## NSW RURAL FIRE SERVICE

15 August 2014

**Lakes Estate Residential Development, North Boambee Valley (MP05\_0129 MOD 1)**

SUBDIVISION STAGE 1 PLAN_Response TO RFS LOTS 1-58 AND PART LOT 141 (RESIDUAL)

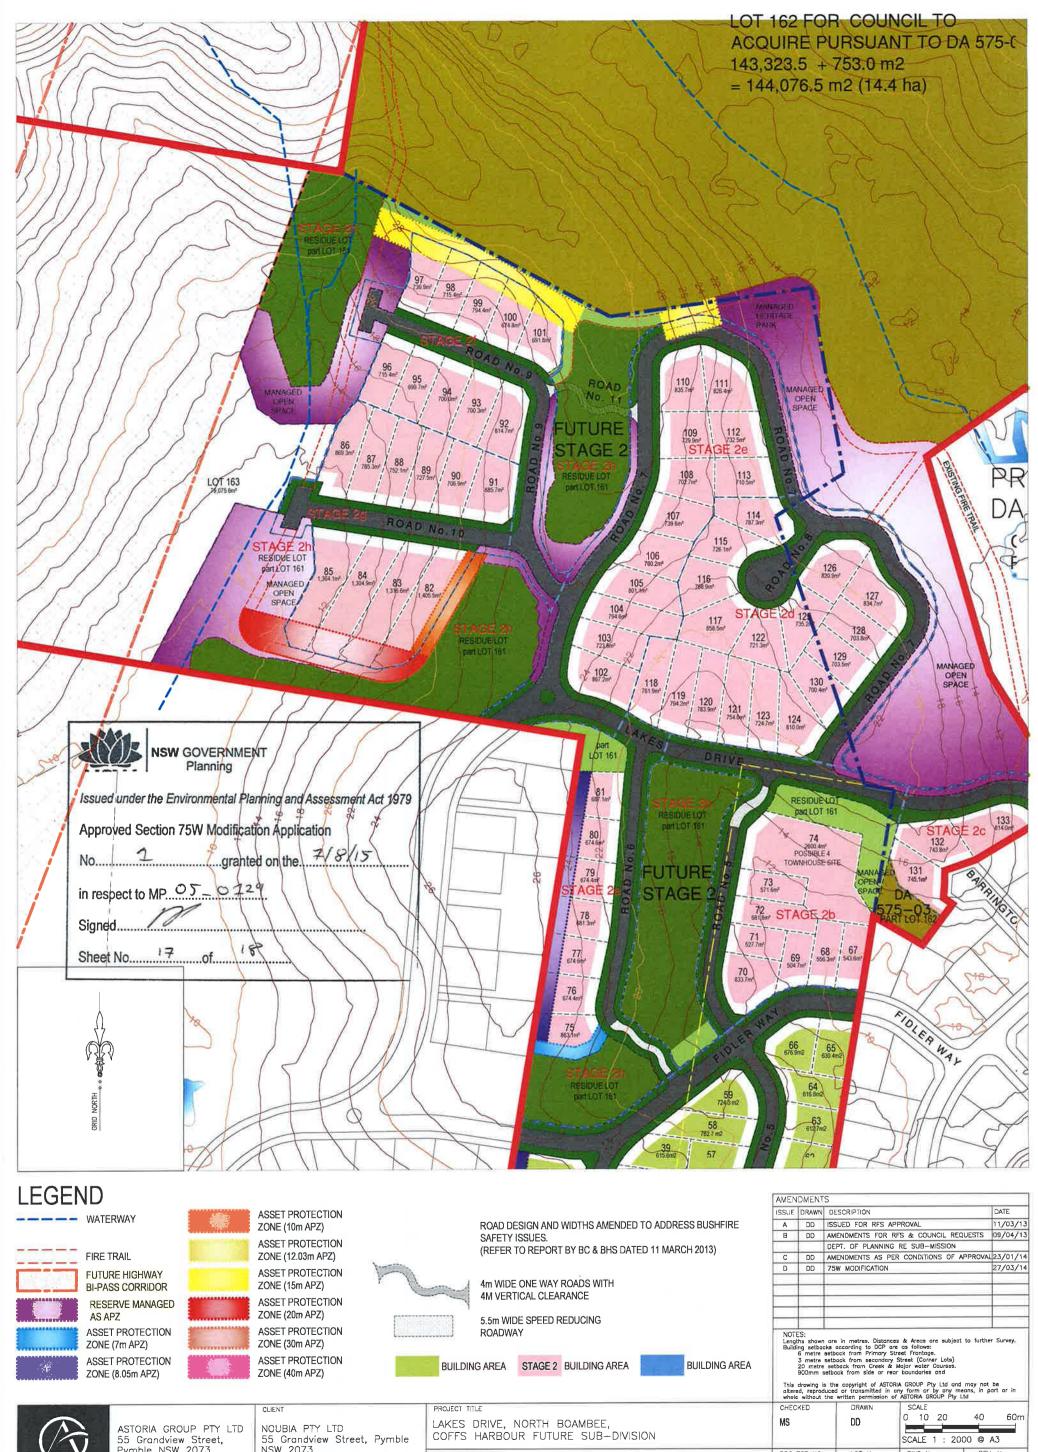
It is also noted that the modified subdivision plans do not include the above asset protection zone requirements. The Services recommends that these amendments be shown on the modified subdivision plans to correctly reflect the approval conditions and to avoid potential confusion due to the discrepancy between the approved plans and approval conditions.
